**Re: Marist Catholic College North Shore (SSD-10473)
Response to Submissions 2**

We refer to the response provided by DPIE dated 20.12.21 to the State Significant Development Application for Marist Catholic Collage North Shore and specifically the comments on the landscape design and provide our response as follows.

- Tree to be retained (39)
- Tree to be removed (63)
- Tree to be transplanted (2)
- Proposed Tree
- Transplanted Tree

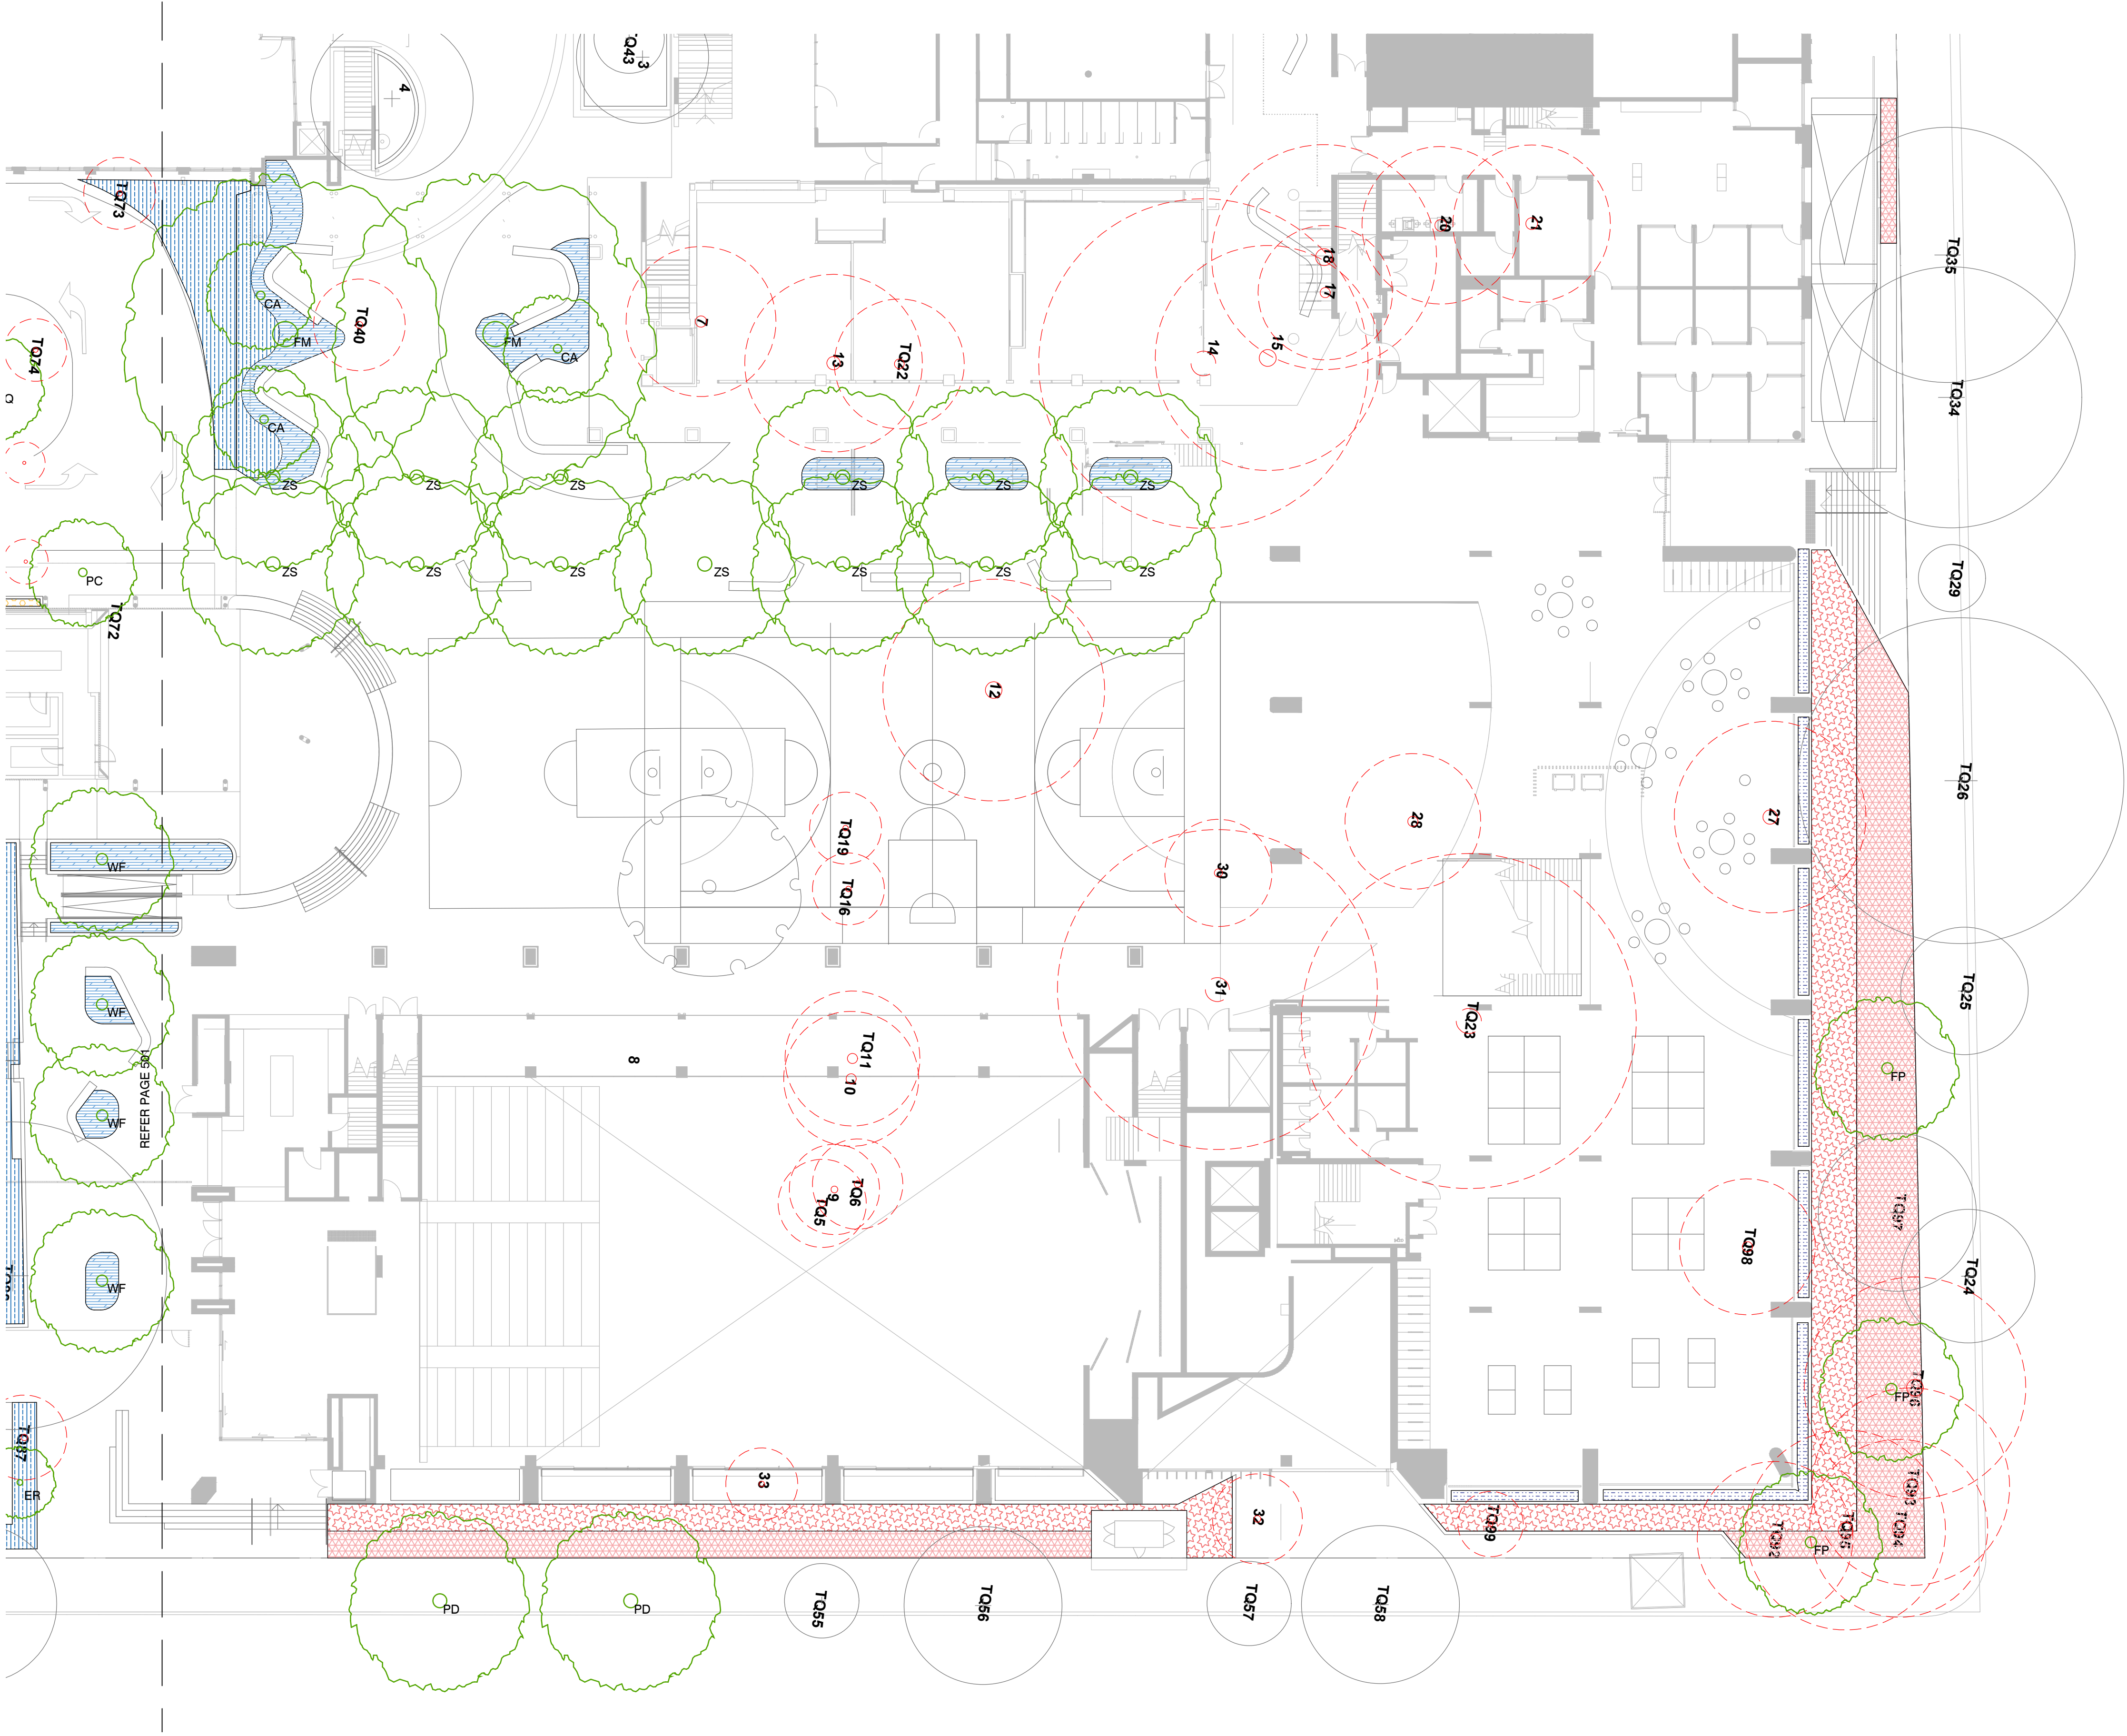
- clarify the total number of trees for removal and retention. In particular, clarify whether the two trees now proposed for retention (transplanting) are included within the calculation of total number of "trees for removal" (59) OR "trees for retention" (17).

- confirm the total number of proposed replacement trees, noting the RtS and Arboricultural Impact Assessment indicate 60 replacements, however, the updated landscape plans indicate 108 (70 at ground level and 38 at roof terrace levels).

Response: There are 44 trees proposed for retention (2 high value, 7 moderate value, 13 low value, 21 unspecified value and 1 un-surveyed).

There are 64 trees proposed for removal (3 high value, 7 moderate value, 47 low value, 2 unspecified value and 5 un-surveyed).

The 2 trees proposed to be transplanted (T8 & T86) are included within the total number of "trees for removal".

Response: There are 114 replacement trees proposed in the updated landscape plans. Refer to L-005 and L-007-009.
